Appeal Decisions

Appeal A: APP/E5330/Z/22/3294073

Lokanta Bar and Grill, 11-13 Greenwich Church Street, Greenwich, SE10 9BJ

Appeal B: APP/E5330/X/22/3294105

SIGNAGE & LIGHTING
 DETAIL SECTIONS
 EXISTING

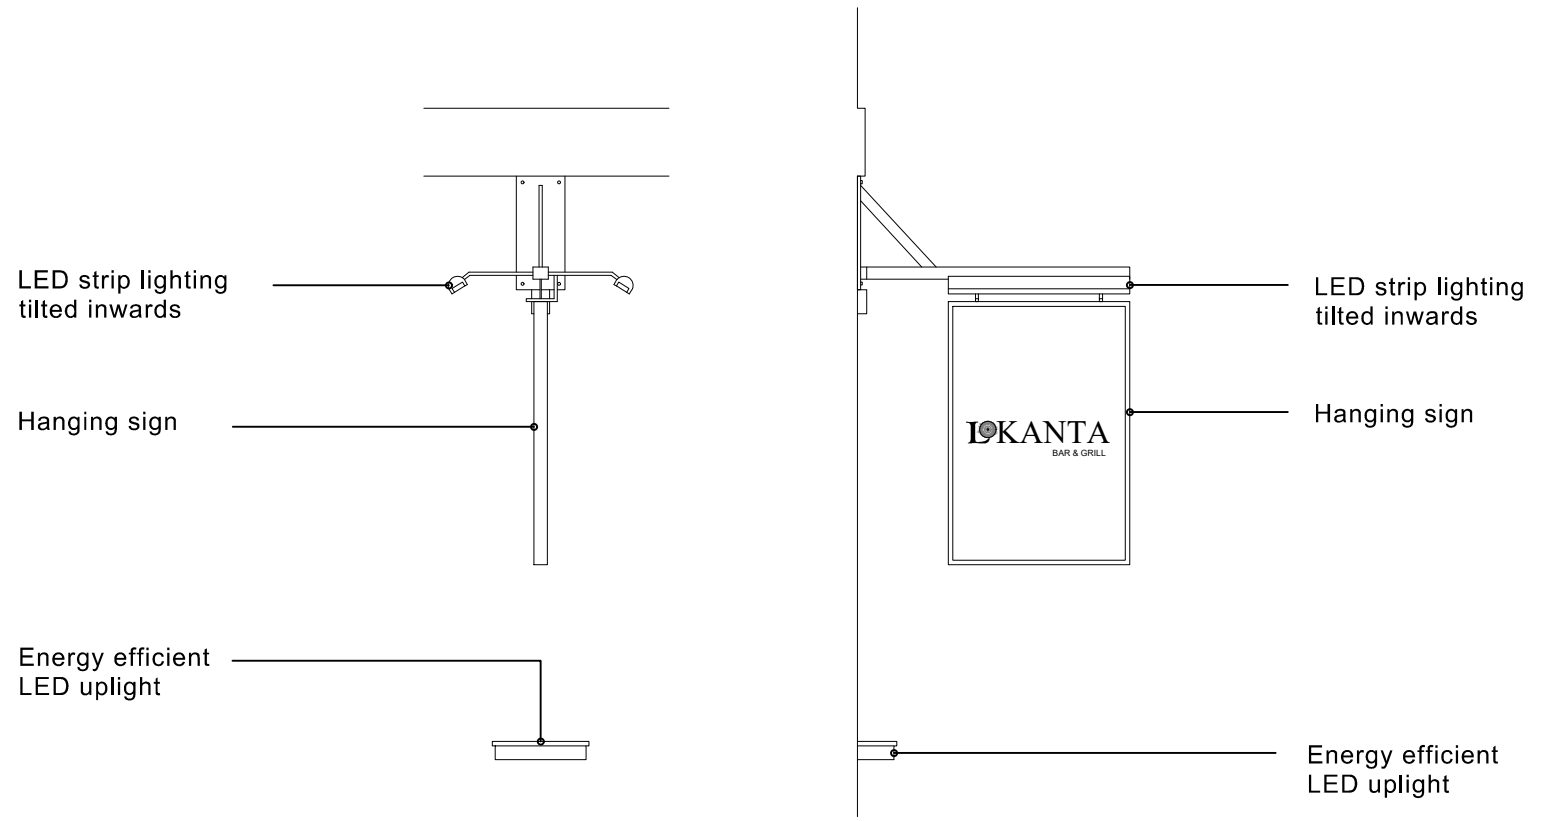
11. The fascia signage is painted onto the existing timber shopfront and in this respect is appropriate to the buildings. However, the trough lighting above it is attached to the cornice which obscures this architectural feature. Furthermore, because it is attached to the cornice the fitting projects more than it would if it had been attached to the fascia and this gives it an awkward and prominent appearance.

13. The illuminated hanging sign is fixed to a plain, utilitarian bracket which has an industrial appearance lacking in any aesthetic detail. It contrasts and jars with the elegant period building to which it is attached. Furthermore, it is large and situated high up on the building above the fascia. As a result it is unduly dominant on the historic façade, visually detracting from the elegant domestic architecture of the listed buildings and it is obtrusive in the street scene.

15. The 5 LED wall lights which illuminate the upper parts of the façade appear as additional clutter on the building and they are not in keeping with the buildings' elegant proportions and simplicity. The appellant says that the uplights have replaced even less attractive lights which they consider were lawful due to a previous consent. However, I do not have documentation to demonstrate that the previous lights were lawful and therefore I am not persuaded that putting them back would be a realistic fallback position.
